Project Address: Proposed Development for 94 Dwelling Units at lands 150m North of the N55, Lissywollen, TD, Athlone, Co Westmeath.

Project Reference: 127

Response to submissions received from An Taisce.

Re: Part 10 Planning Application – Proposed Development of 94 Dwelling Units at Lands 150m North of the N55, Lissywollen TD., Athlone, Co. Westmeath

Proposed Site Layout - Overall Layout
1 : 1000

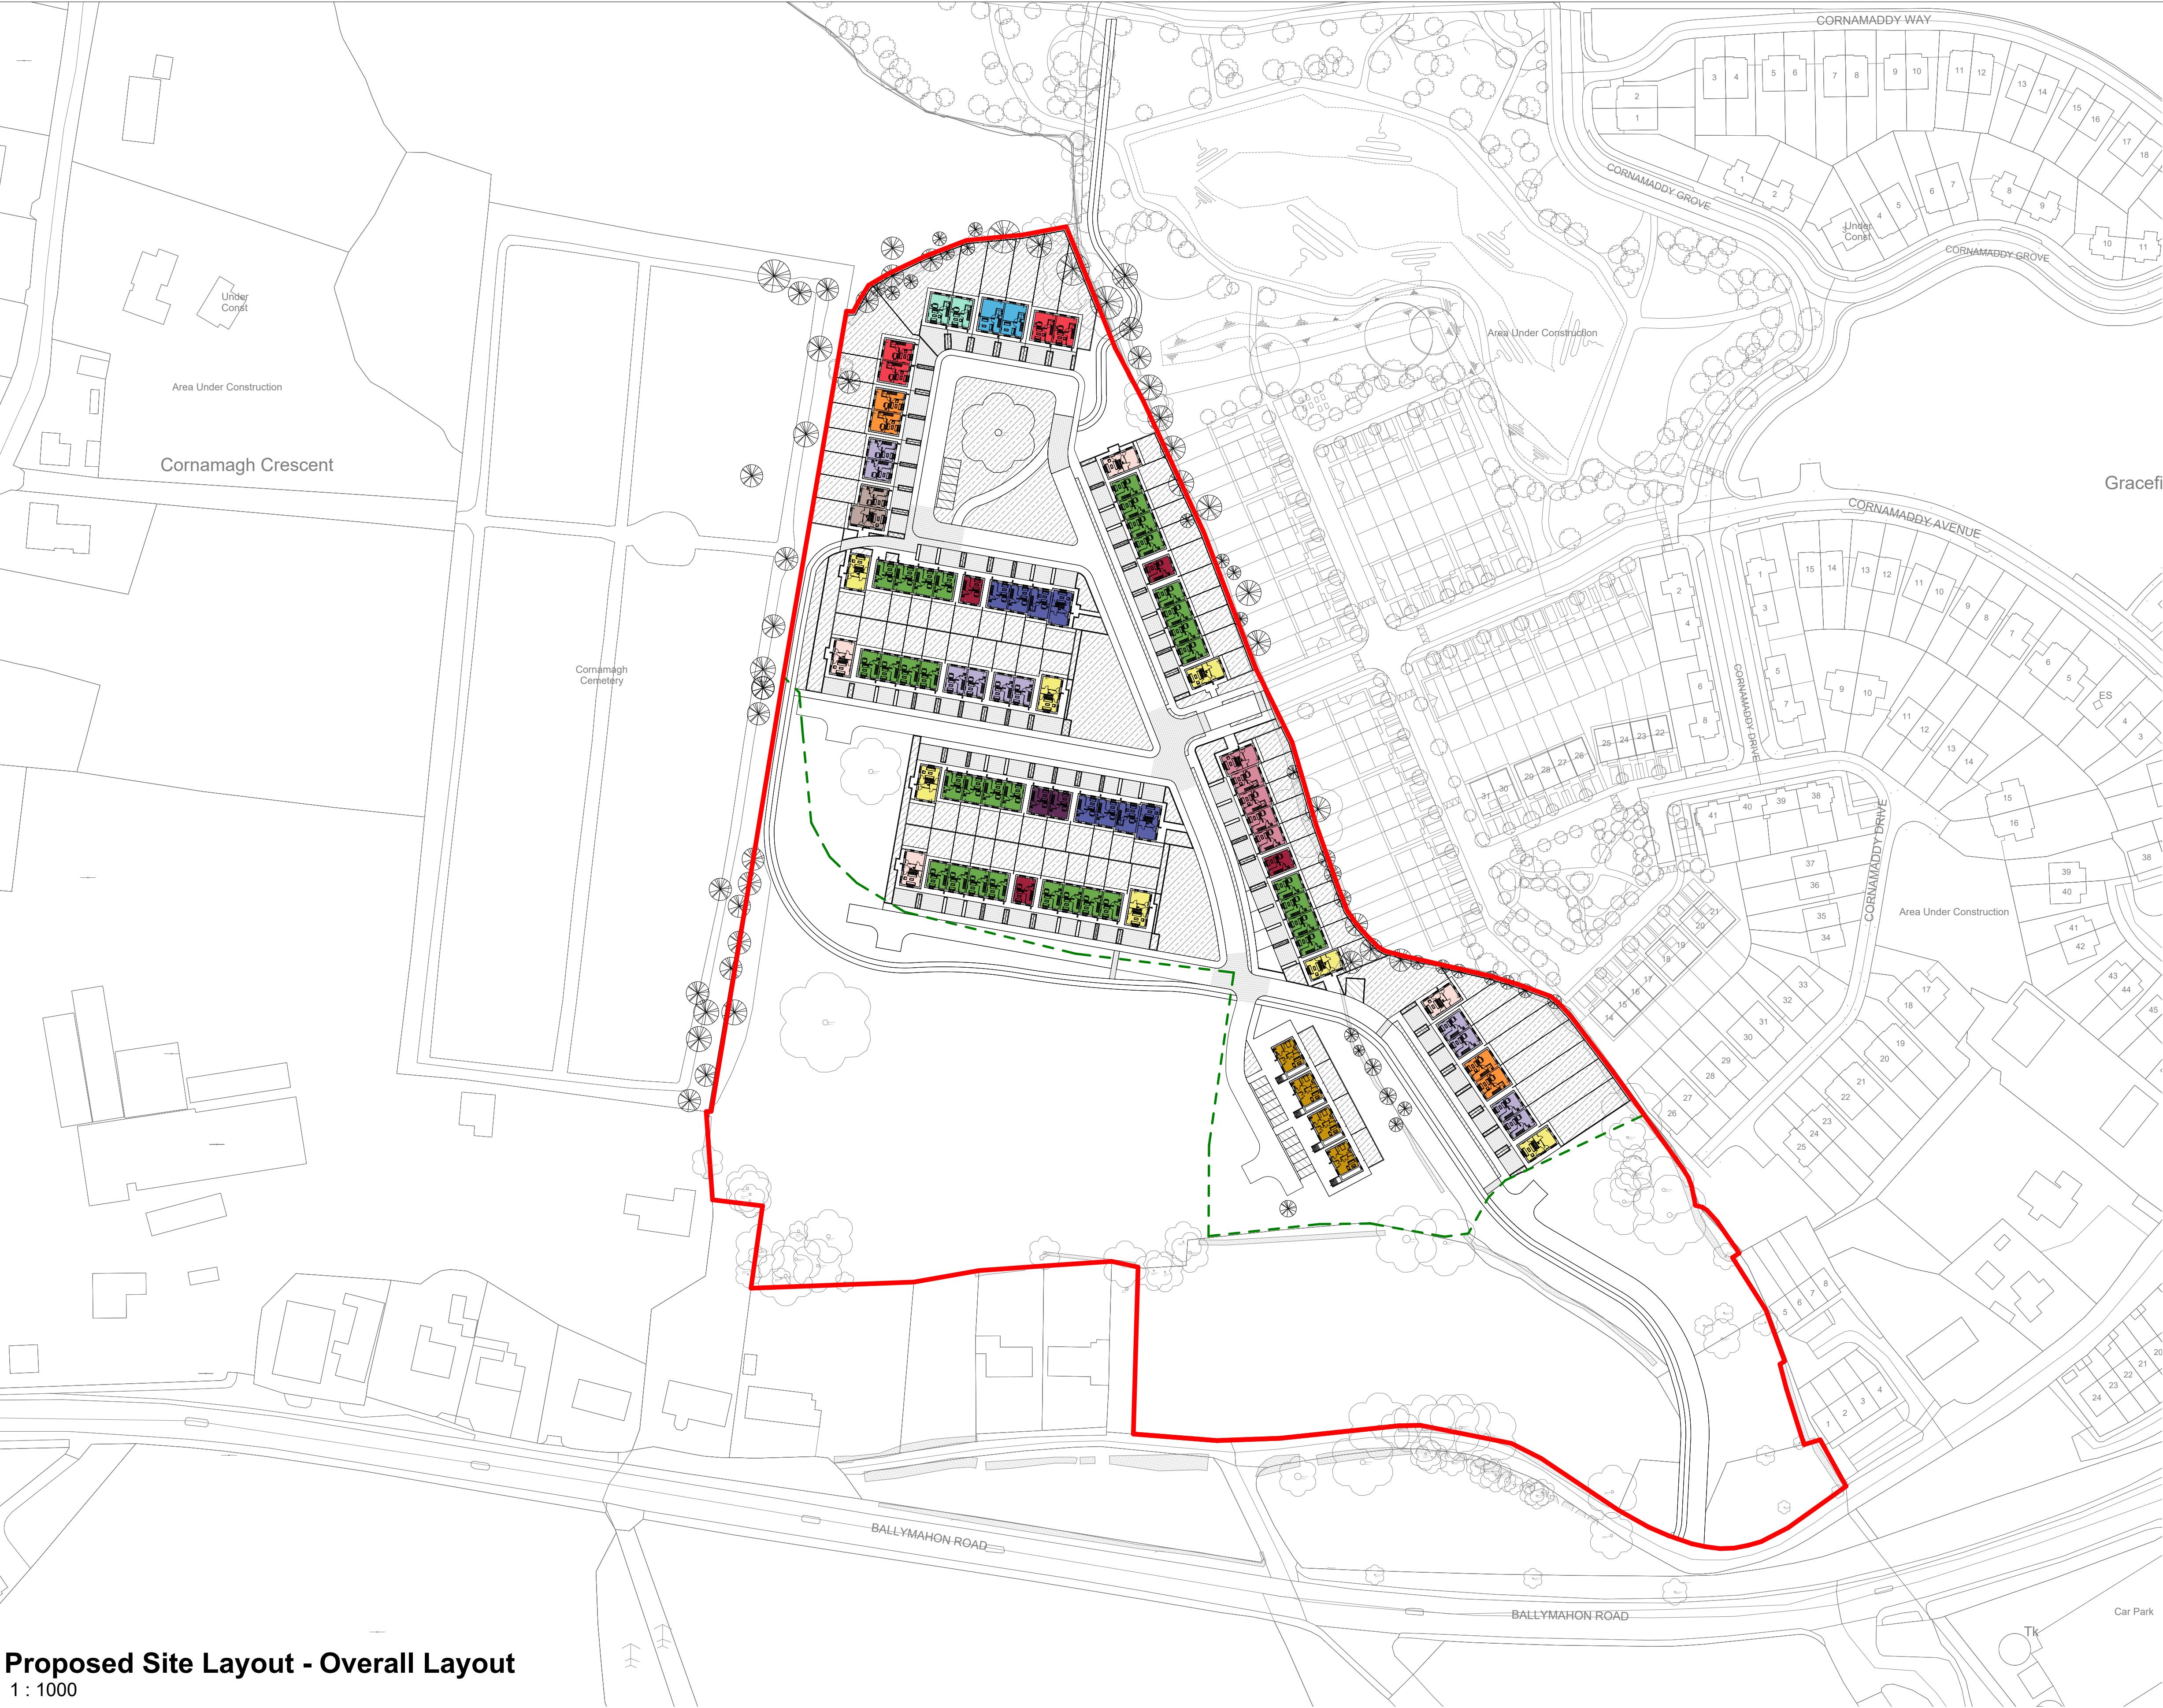
Therefore, although a new residential development may provide high quality foot and cycle permeability around the dwellings, these often terminate immediately outside the site boundary, thereby discouraging from using active travel modes outside of the development itself and thereby increasing car dependence.

It should be ensured that the subject proposal's design adheres to the need to promote a modal shift towards increased pedestrian, public transport and cycle friendly development, in adherence to the

National Sustainable Mobility Policy and the Compact Settlement Guidelines. Access to public transport links and cycling/pedestrian infrastructure outside the subject site boundary is a crucial consideration.

With regard to permeability, the Council should have regard to the NTA's guidance which emphasises how permeability contributes to the attractiveness of a neighbourhood. The proposal should also demonstrate adherence to CPO 16.25 within the Westmeath County Development Plan 2021/2027 which specifies the following:

Be based on layouts where all streets lead to other streets, limiting the use of cul-de-sacs that provide no through access.

Maximise the number of walkable / cyclable routes between destinations. (p. 41)"

The proposed development offers a strong walking and cycling permeability within the boundary of the site, where the generous footpaths are combined with raised 'table top' junctions to provide traffic calming measures and safe pedestrian zones that allow the footpaths and cycle paths to connect to the north south active travel route and provide various routes for cycling and walking within the site boundary.

The design team consulted the Westmeath County Council 'Active Travel' team when considering the cycle and pedestrian access routes. The proposed development will connect to and extend the Westmeath County Council active travel 'route D'. Please refer to the design report and site plan which clearly sets out the proposed extension of active travel routes through the site, these routes reinforce the proposed development sites safe cycling and walking routes to local facilities such as, the greenway, public transport, schools, local services, employment centres, recreation areas. Furthermore, the proposed 94 housing units are considered an infill development in an outer suburban area, this proposal will extend and reinforce the safe walking and cycling access as it will act as a pedestrian / cycling link to the existing developments on the north-east outskirts of the town.

# **Tree Protection /**

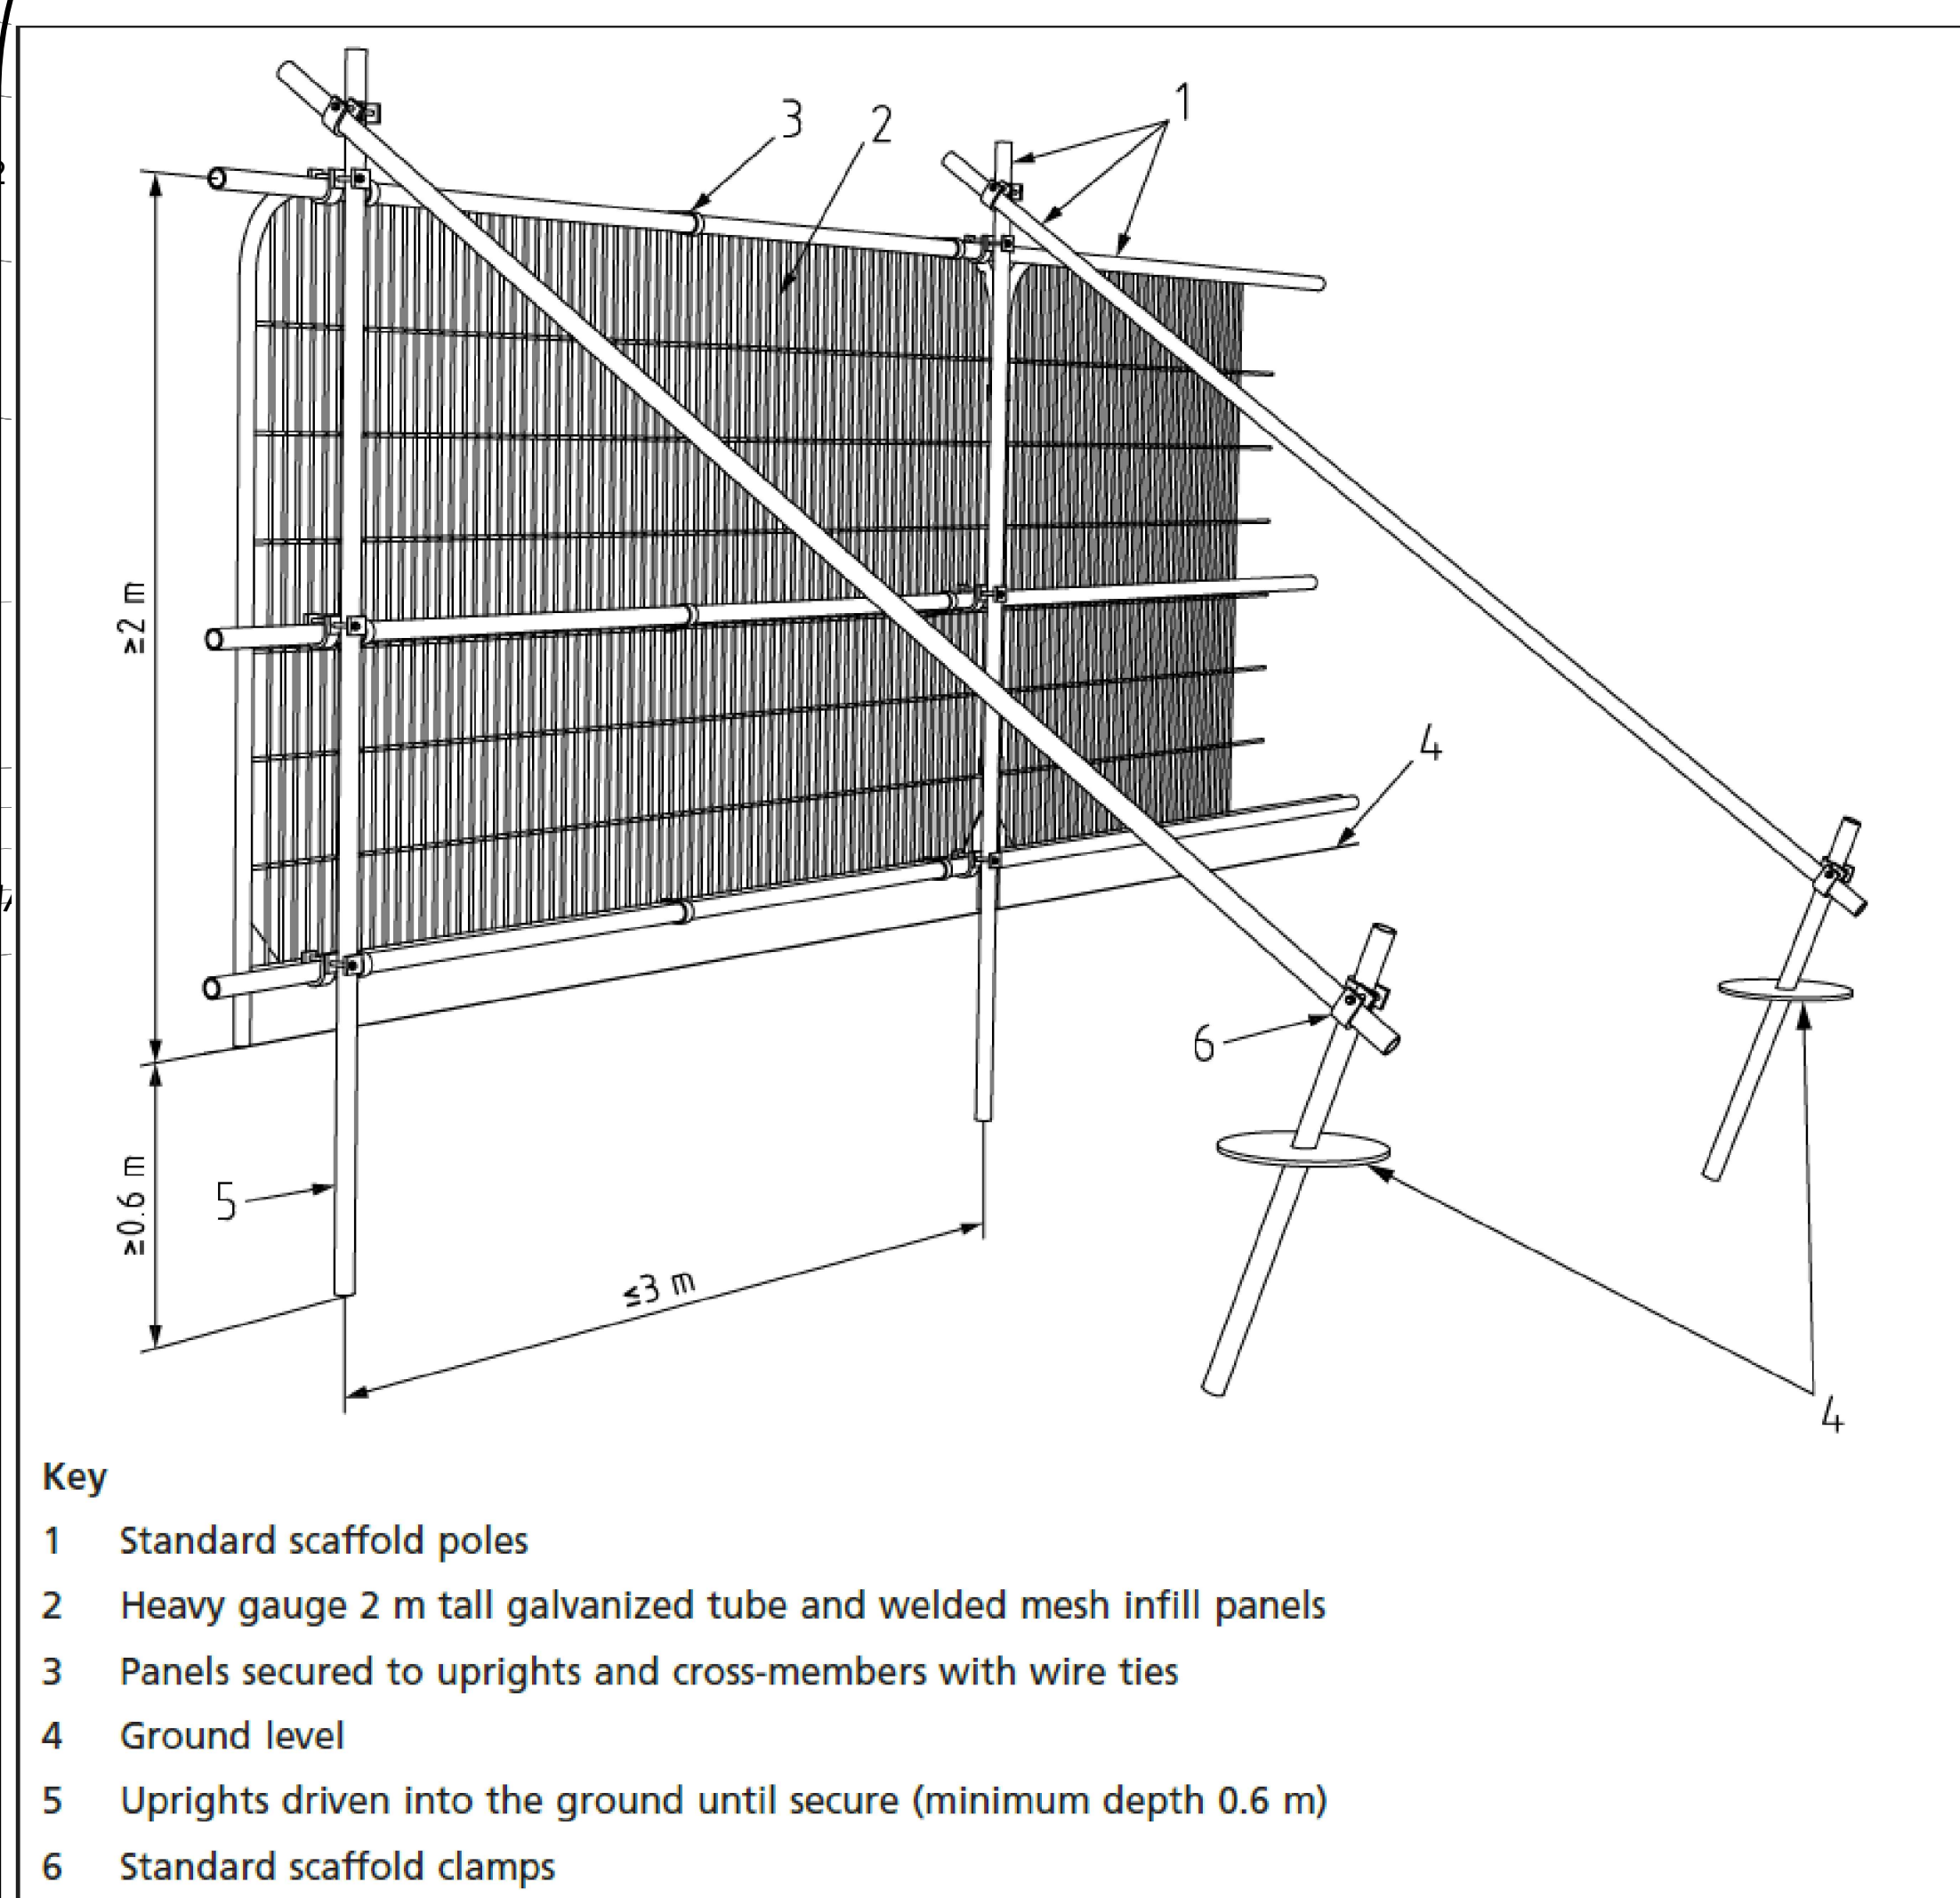
We would recommend that existing trees and hedgerows on site should be retained in the first instance to preserve existing biodiversity and ecosystem services such as flood attenuation, carbon sequestration and wildlife habitat provisioning. It is highlighted that the proposal should demonstrate adherence to CPO 12.37-12.47 with regard to tree and hedgerow preservation. This would also satisfy Article 10 of the Habitat Directive which specifies the following:

Please refer to the design statement submitted with the application documents and also the Arborist report and tree protection plan, which clearly outlines that:

“The proposed development has been planned based on the retention and protection of the existing mature trees and hedgerows by forming the mix of detached, semi-detached, terraced houses, maisonettes, and 2–3-storey duplex apartments into courtyard arrangements around and adjacent to the trees to protect the natural environment, flora and fauna, and habitat resources.”
